My reference: 3/2025/0639
Direct Dial: (01200) 425111
www.ribblevalley.gov.uk
Email: planning@ribblevalley.gov.uk
Date: 7 October 2025

Location: Springwood Whalley Road Hurst Green BB7 9PN
Proposal: Approval of details reserved by condition 10 (building recording and analysis) of planning permission 3/2023/0814.

An updated Level 2-3 Historic Building Recording document (*AB Heritage Archaeological Consultancy Level 2-3 Historic Building Recording dated 30/07/2025*) has been submitted and the Historic Environment Unit re-consulted.

Figure 5: Cruck 1

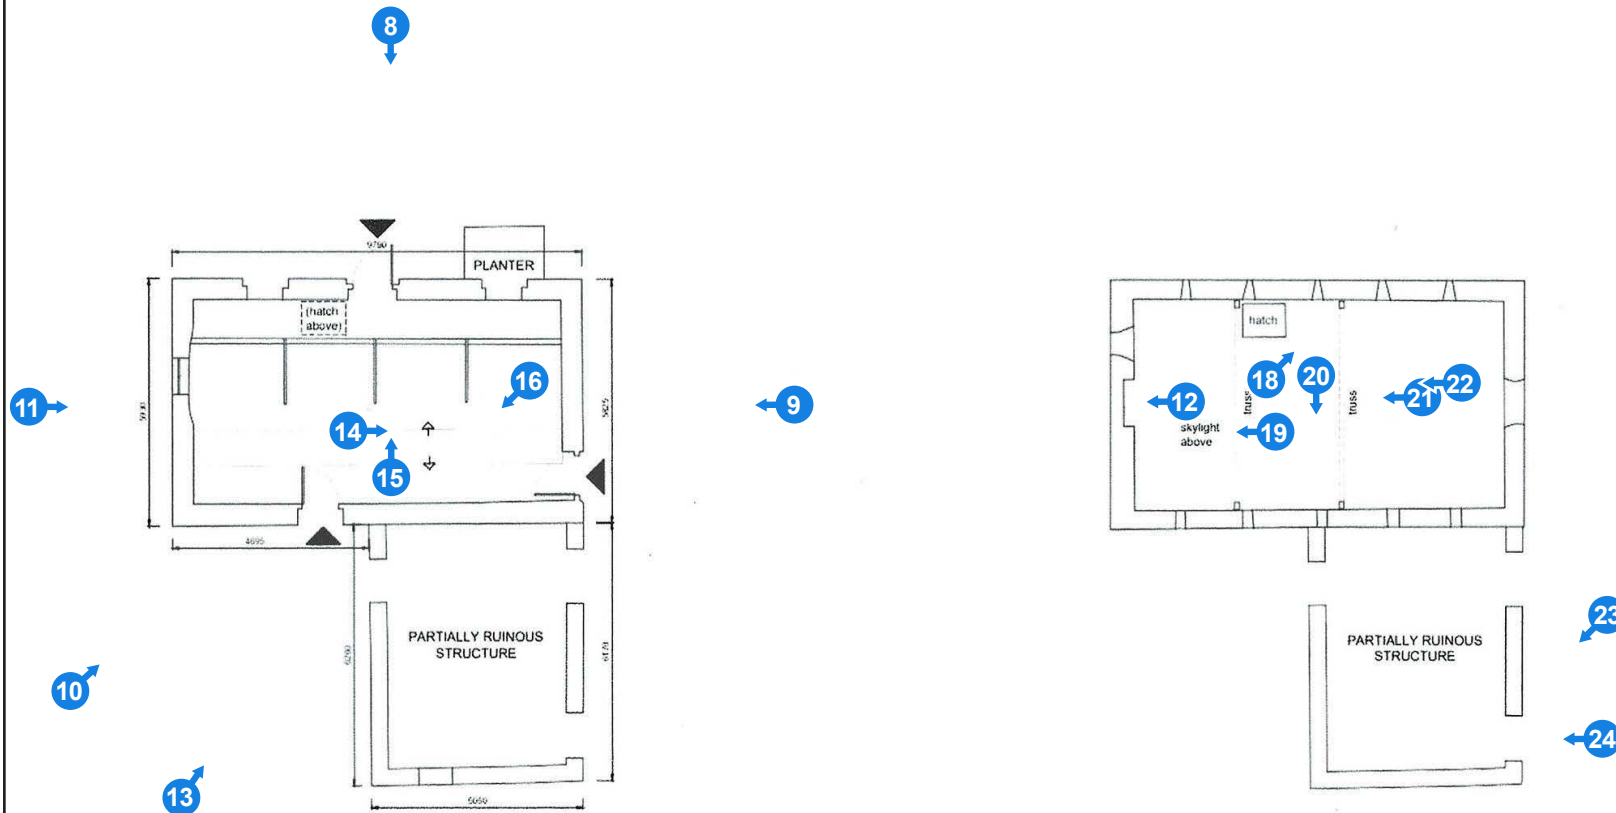
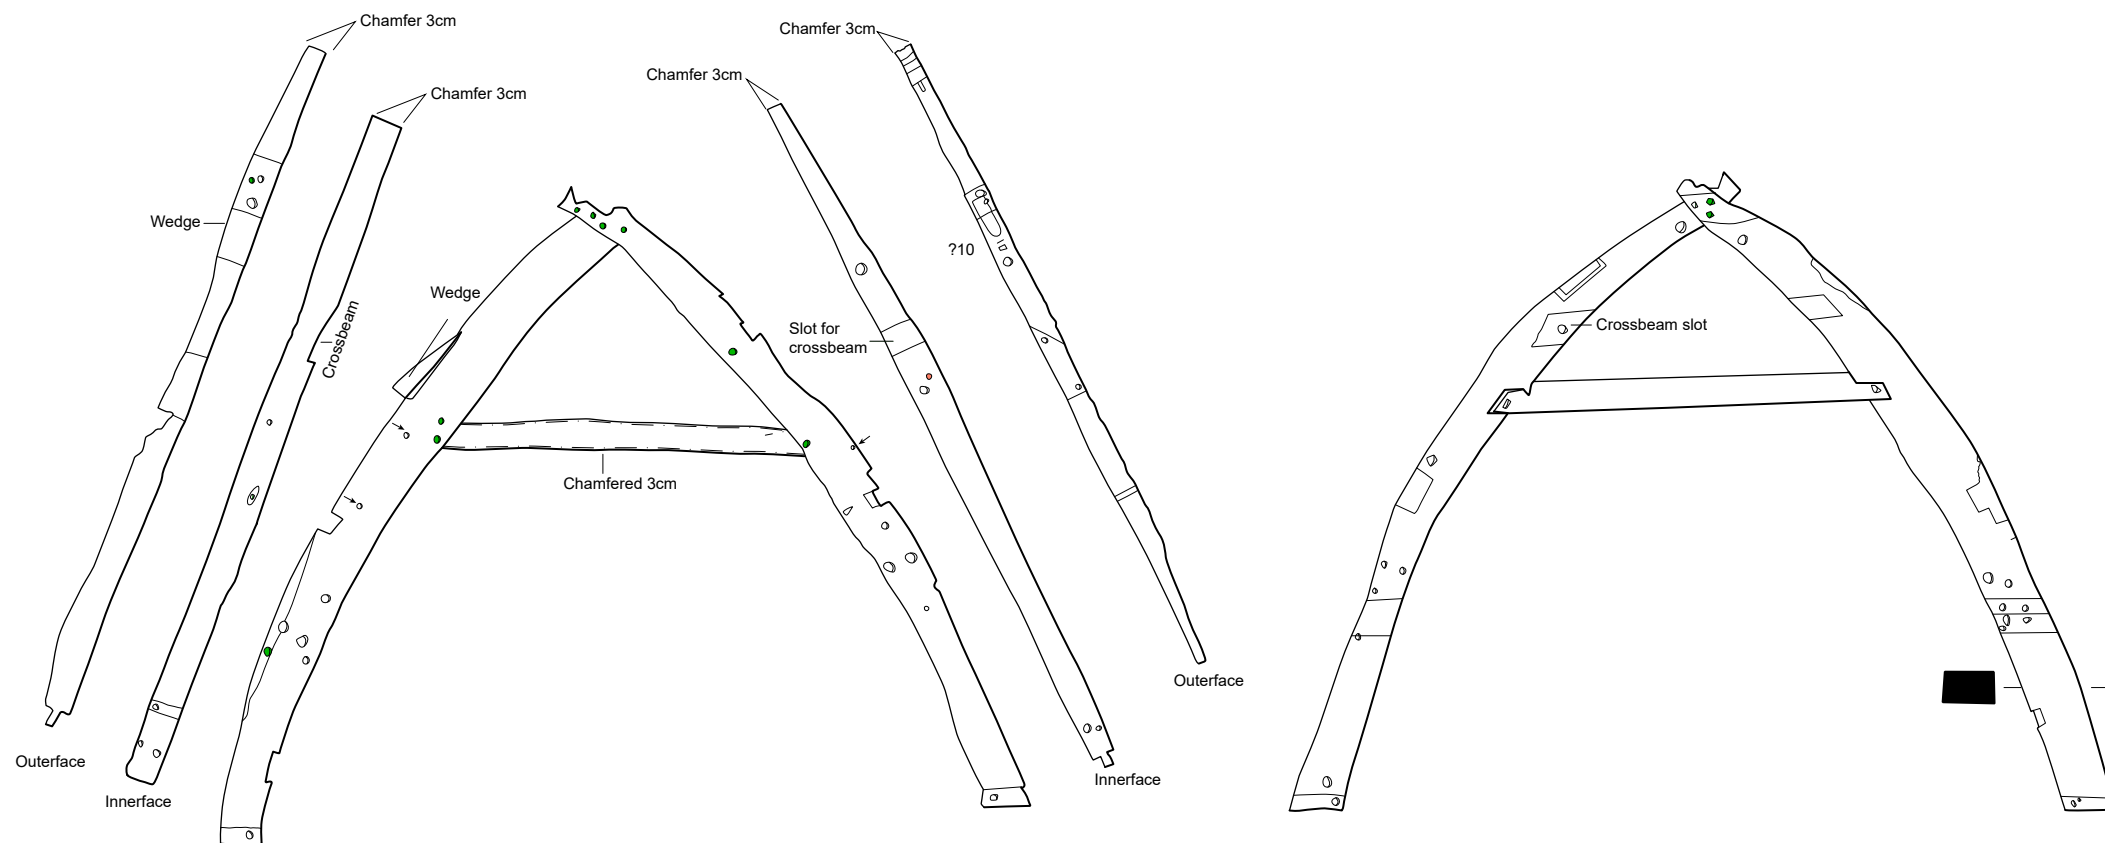
The missing section drawings of the crucks have now been provided.

The Historic Environment Unit consider that the application cannot be discharged in full and only in part as the matter of dendrochronological dating of the timbers of the cruck truss timbers has not been addressed. They consider that whilst the applicant considers that there may be some difficulty getting appropriate samples for dendro dating, this has not been informed with advice from a specialist in dendrochronology and a formal assessment of the timbers by a specialist would be needed and the fact that the timbers have woodworm and are decayed "in places" doesn't necessarily preclude them from being able to produce suitable samples.

The applicant is required to submit an assessment of the timbers and advice in relation to the dendro-dating from an appropriate specialist.

As such, the condition is **discharged in part** but cannot be fully discharged until a dendrochronology study is provided or a reasonable justification is provided for omitting this.
